Please show 2010 ADA Standards compliance with door, toilet room and fixture clearances.

86 PONDFIELD ROAD WEST, BRONXVILLE, NEW YORK 10708
 DIAMOND COVE GENERAL STORE
 RESTROOM INTERIOR ELEVATIONS AND MOULDING DETAILS
 NASTASI VAIL DESIGN, LLC
 MRS. ALEXANDRA WIGHT
 GENERAL STORE, GREAT DIAMOND ISLAND
 PORTLAND, MAINE 04109

DATE: 1/24/18
 SCALE: 3/4"=1'-0"
 SHEET: 11.5

5 RESTROOM: NORTH ELEV.
 Scale: 3/4"=1'-0"

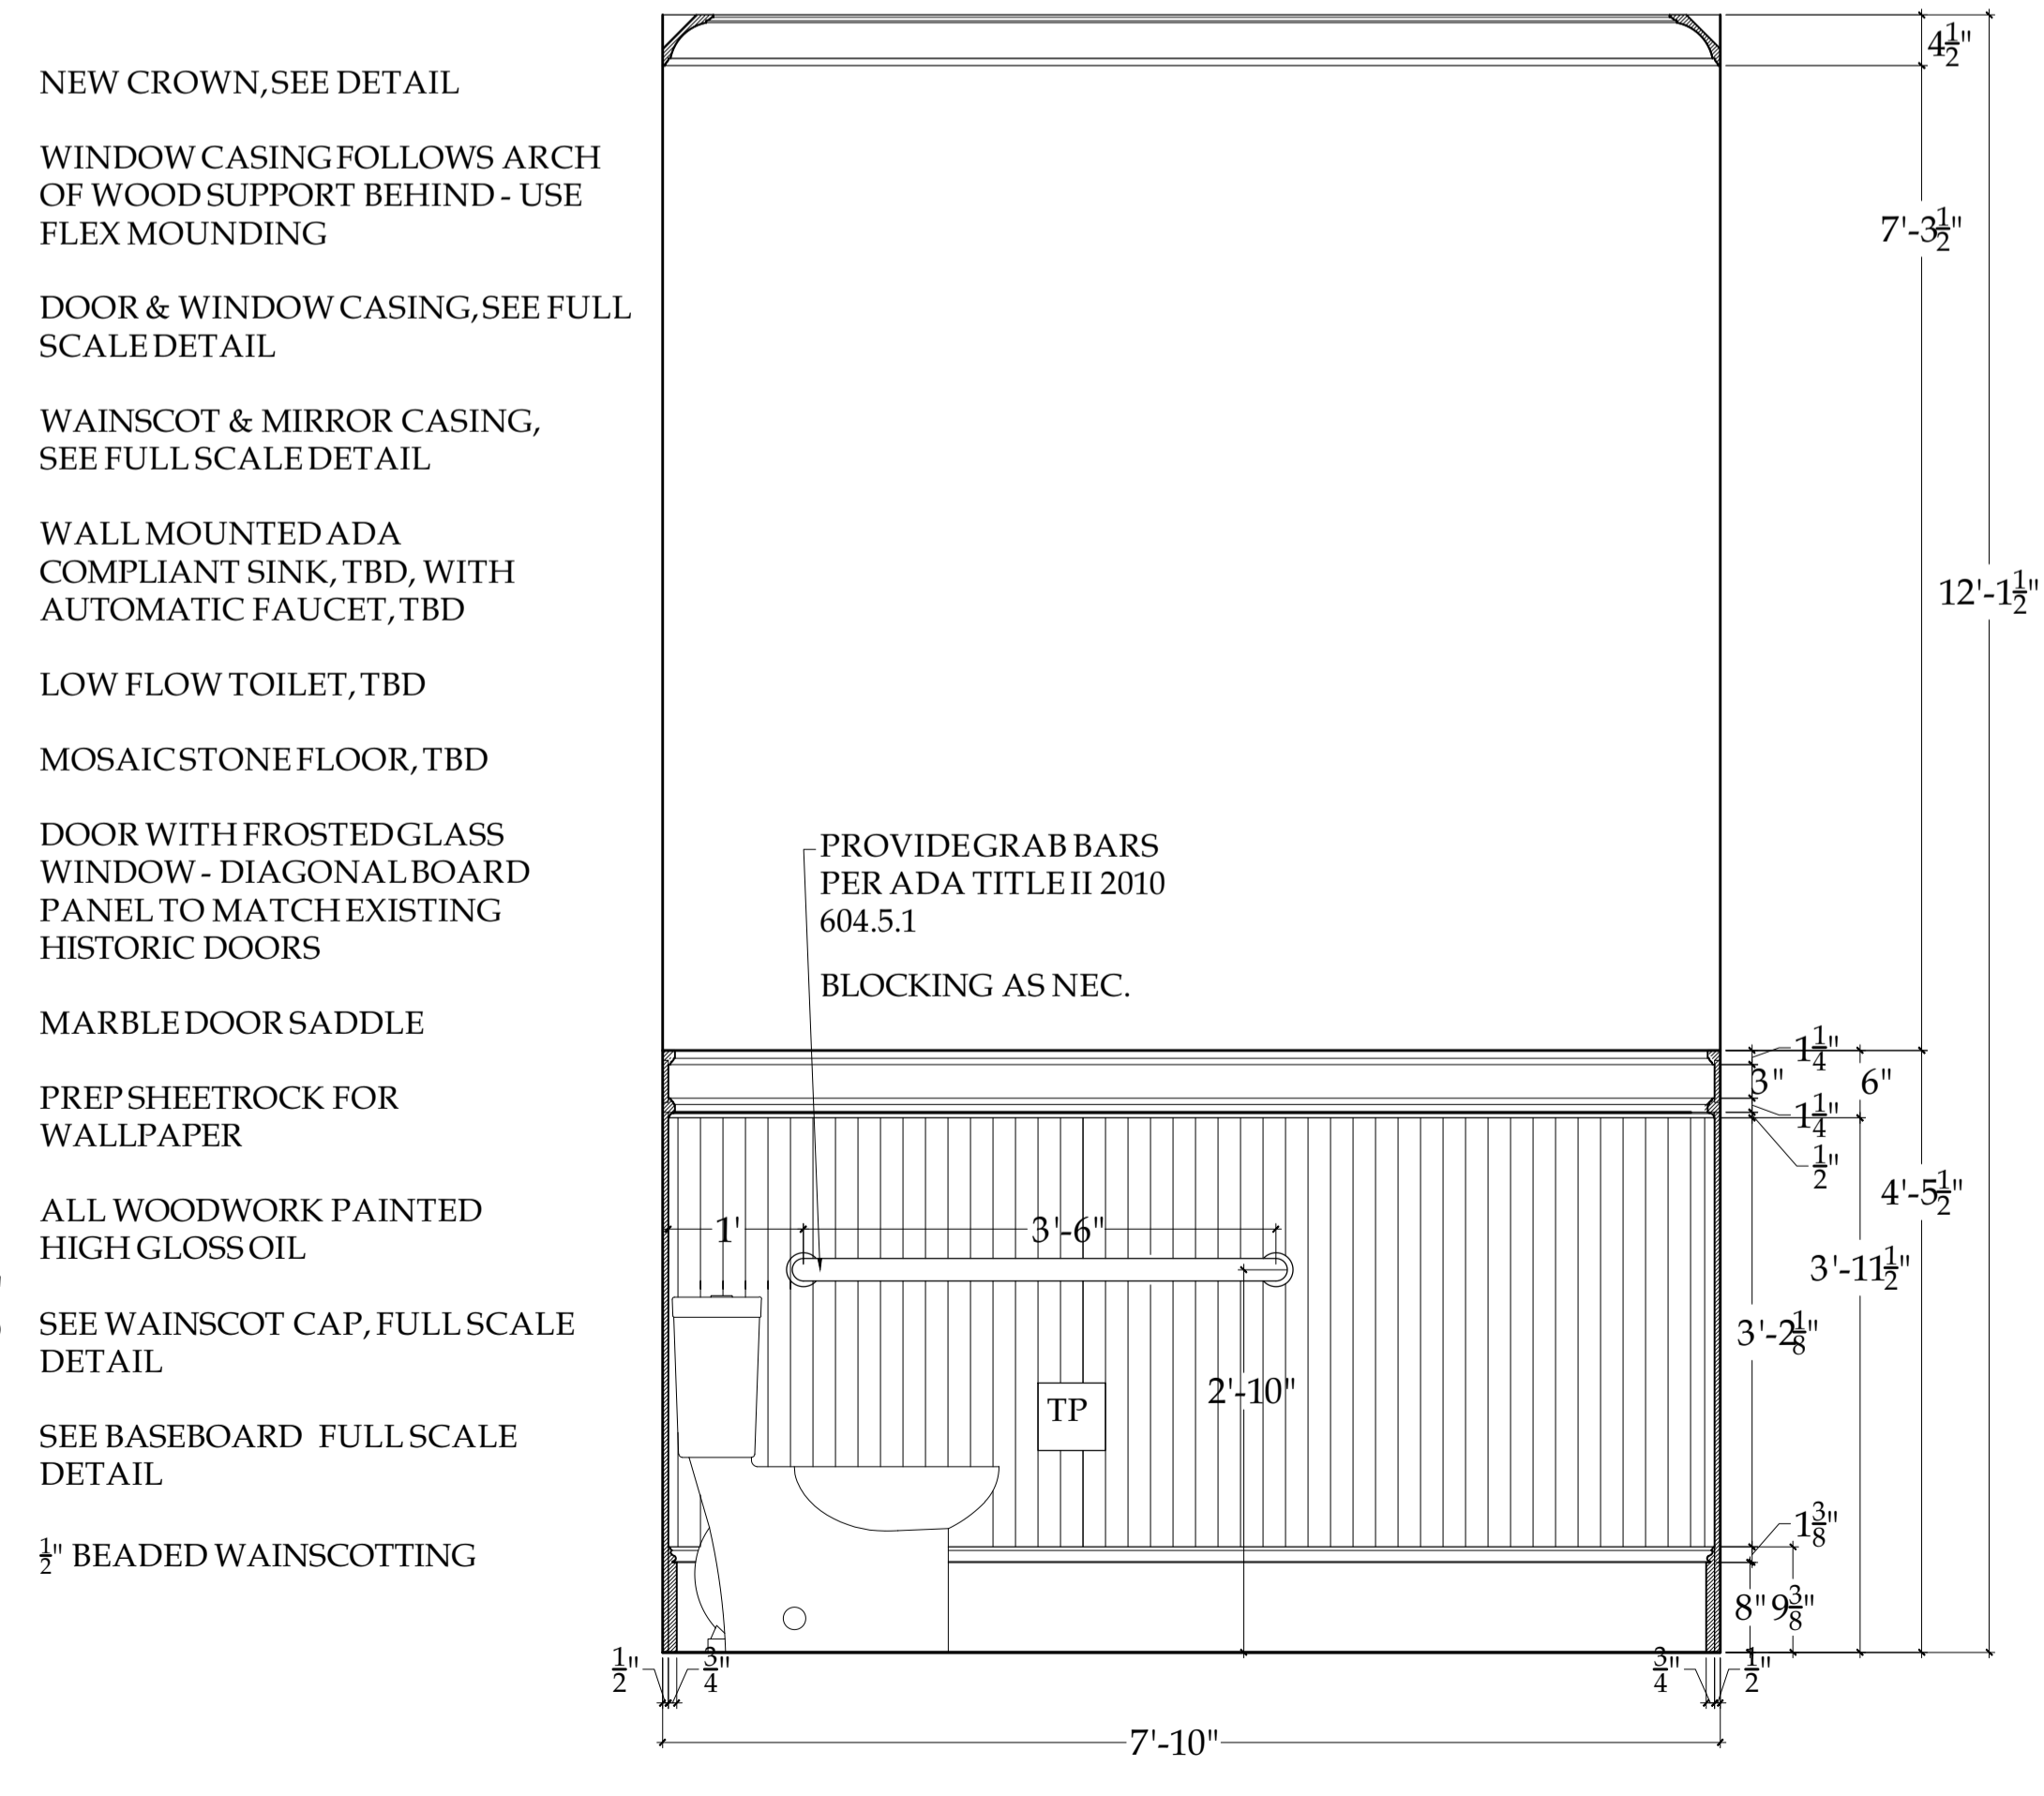
Show ADA compliant knee and toe clearance below sink

Show UPC and ADA compliant distance from wall
